City of
Doncaster
Council

Issue Specific Hearing 1 (ISH1)

Response to Landscape and Visual Questions

Project: Tween Bridge Solar Farm (EN010148)

Figure 6.4: Landscape and Visual Mitigation Strategy

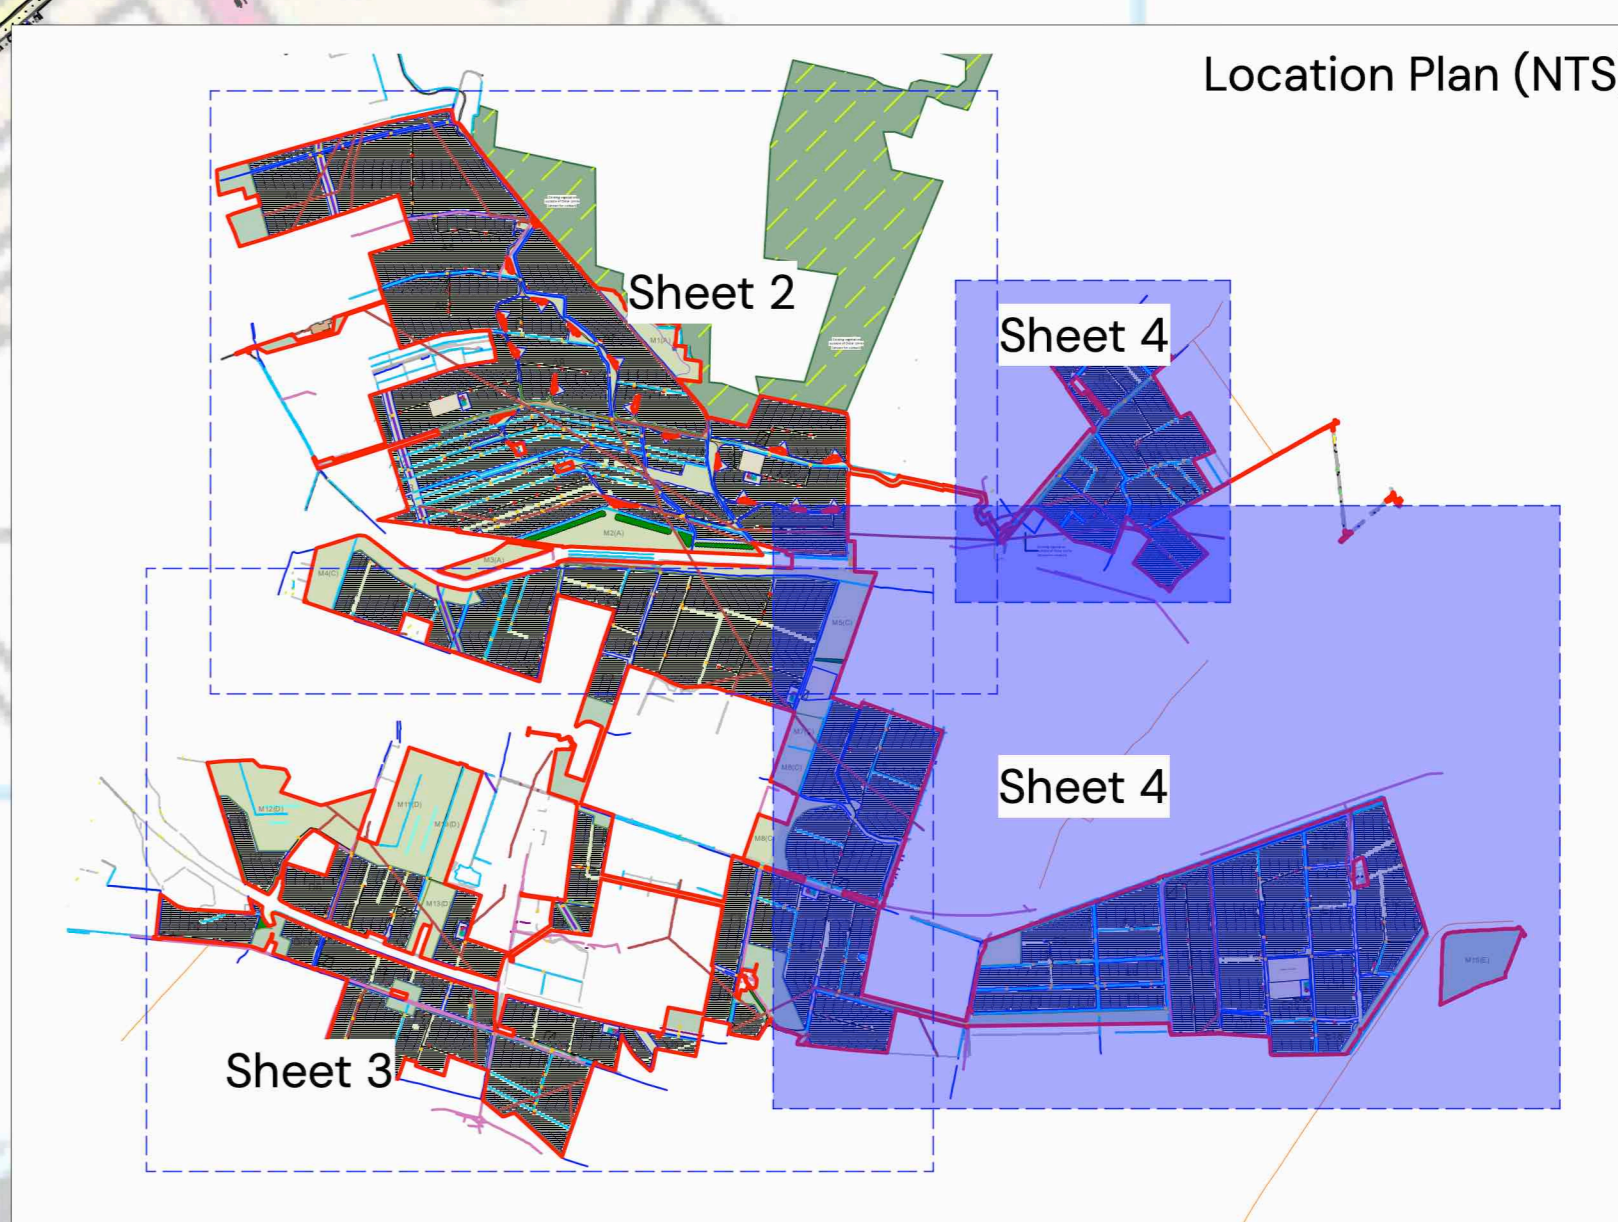
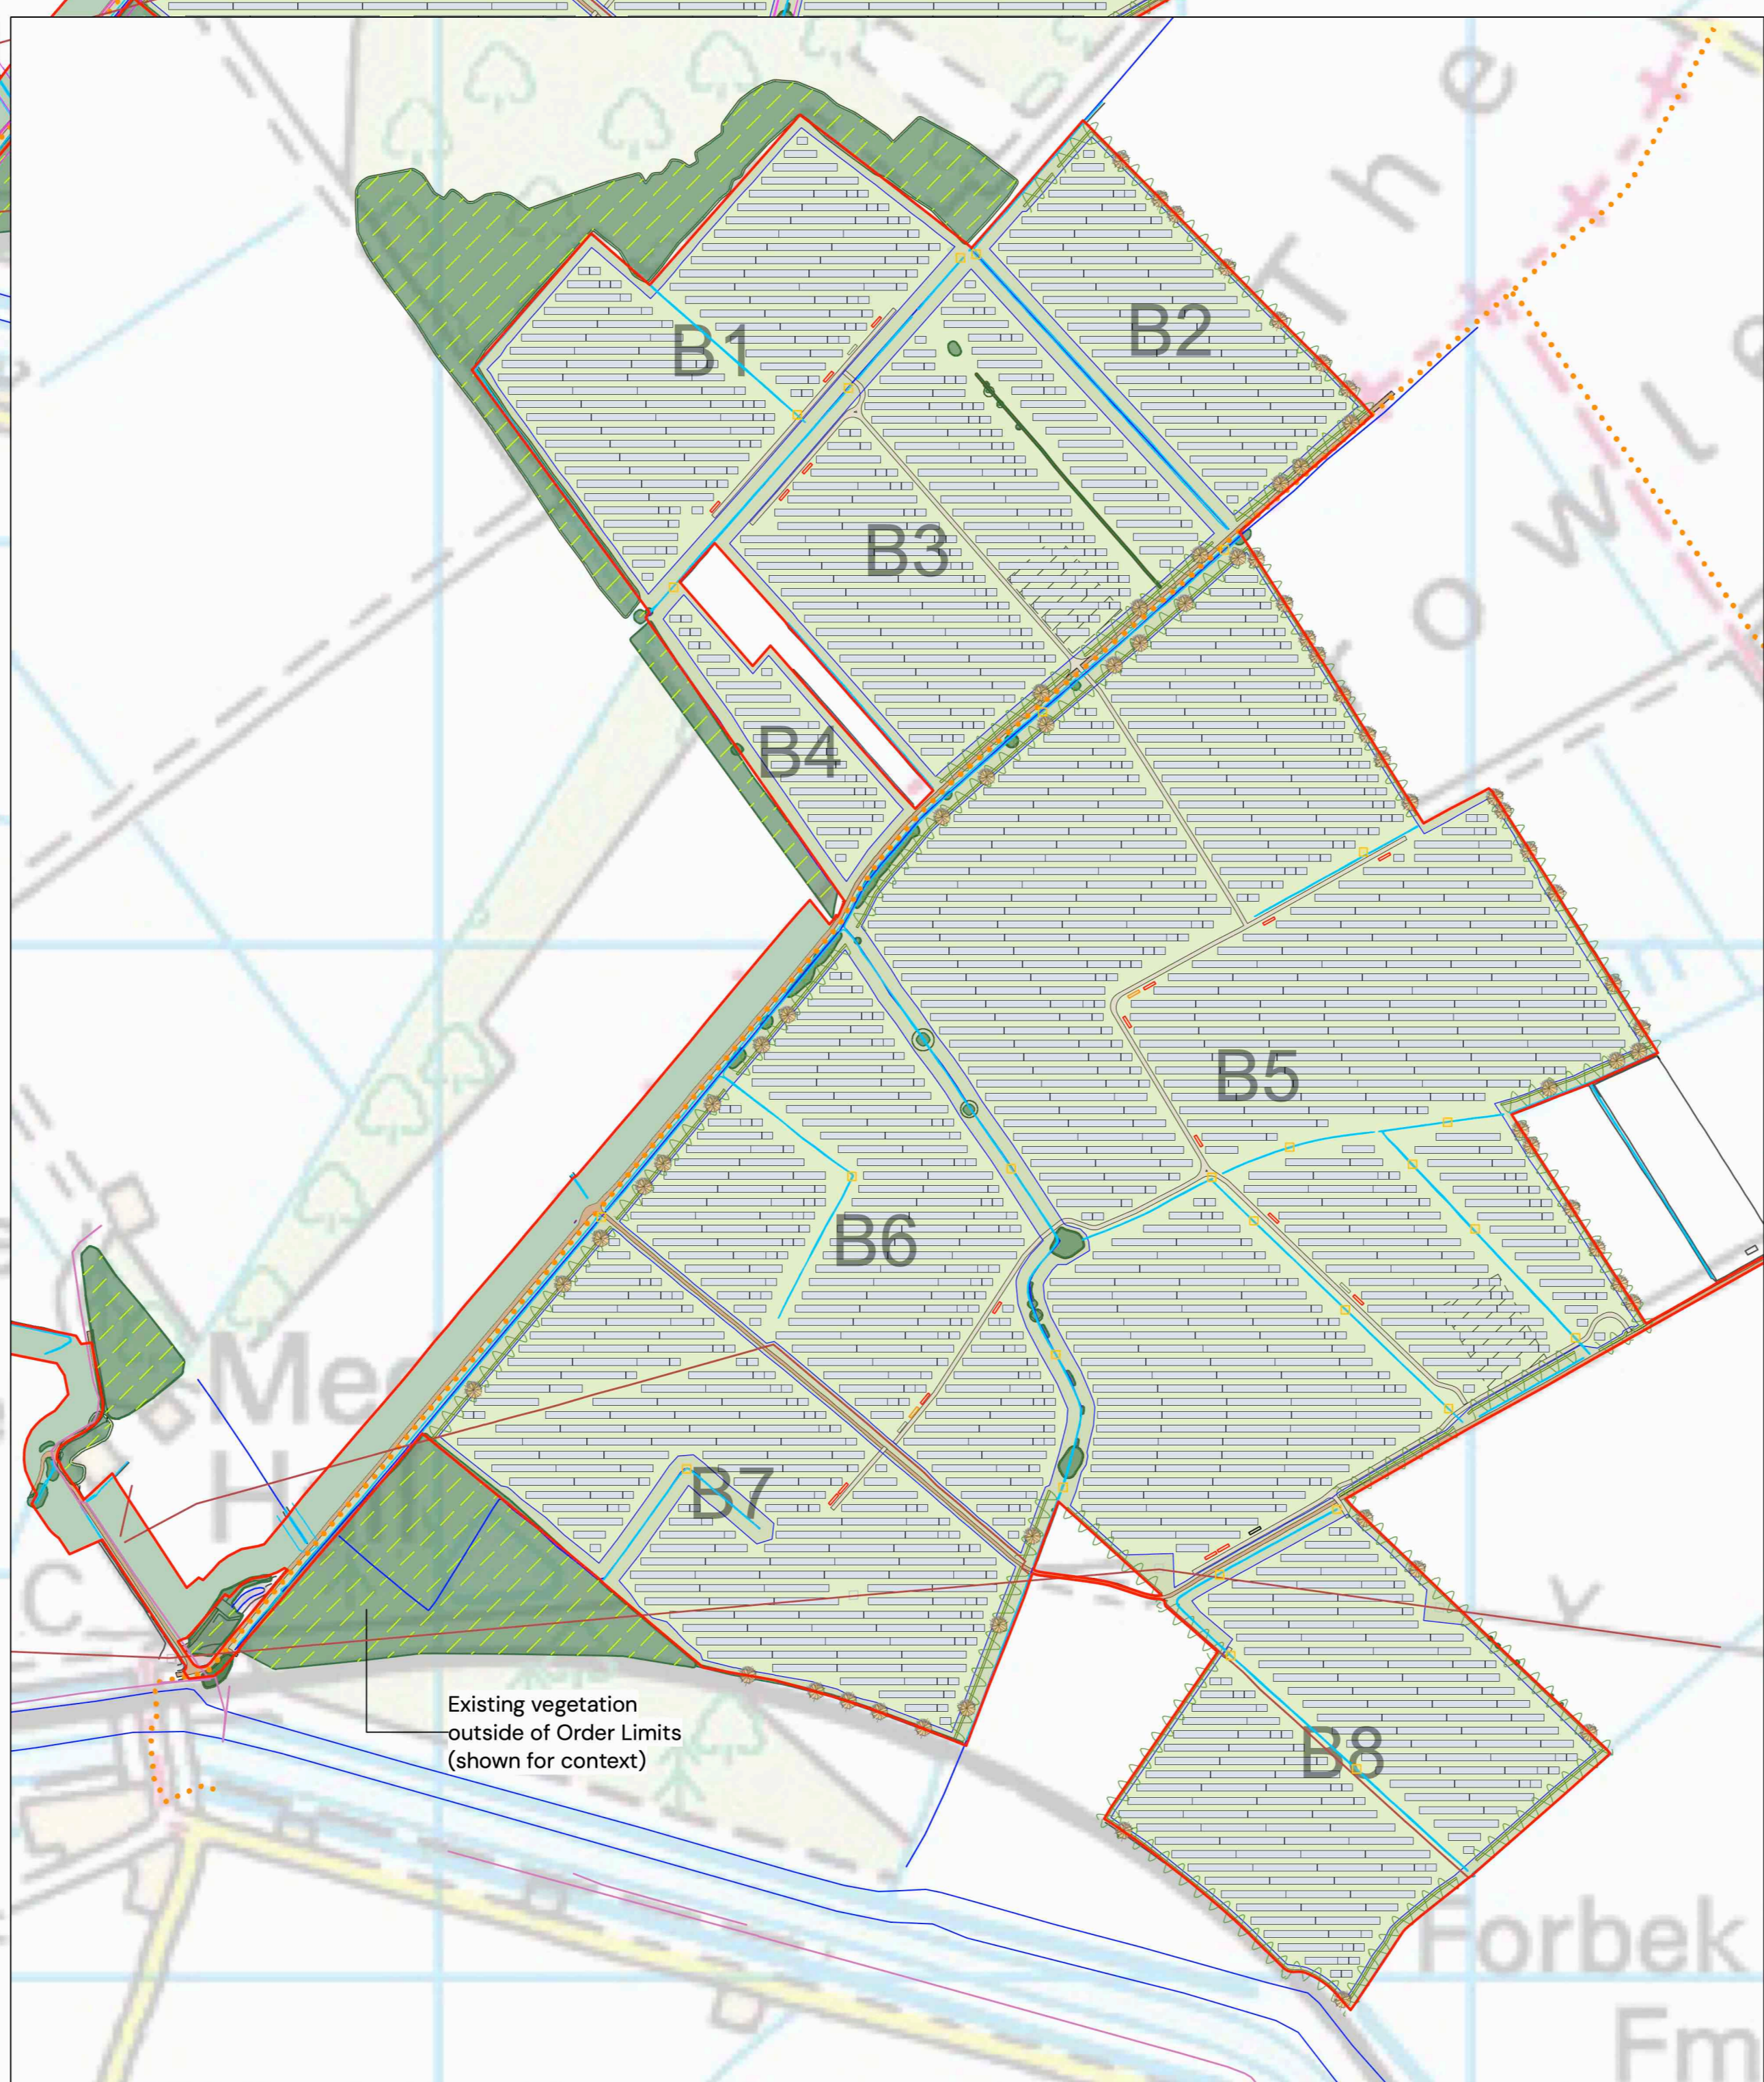
During the Issue Specific Hearing relating to landscape and visual matters there was in depth discussion with regards to the off site 400kv sub station and associated cabling, however, it is note that there is also a proposed onsite 400kv substation; the location of which is not clear. Referring to **Document Ref 6.4.6.5**, Figure 6.5 Residential Properties, the 400 kv substation is shown within Land Parcel E alongside a 132kv substation and BESS. Referring to **Document Ref 6.4.6.4**, Figure 6.4 Landscape and Visual Mitigation Strategy, the 400kv substation is absent from

the drawing, rather it shows an area of grassland. Viewpoint 26, which is supported by a photomontage, **Document Ref 6.3.6.4** Appendix 6.4 Photomontage Visualisations, is the closest viewpoint to the location of the 400kv substation location, but the substation is not depicted on the photomontage, nor is its likely location labelled. Clarification is therefore sought with regards to the location of the 400kv substation and the route of any associated cabling so that it is clear as to whether it has been adequately considered and assessed.
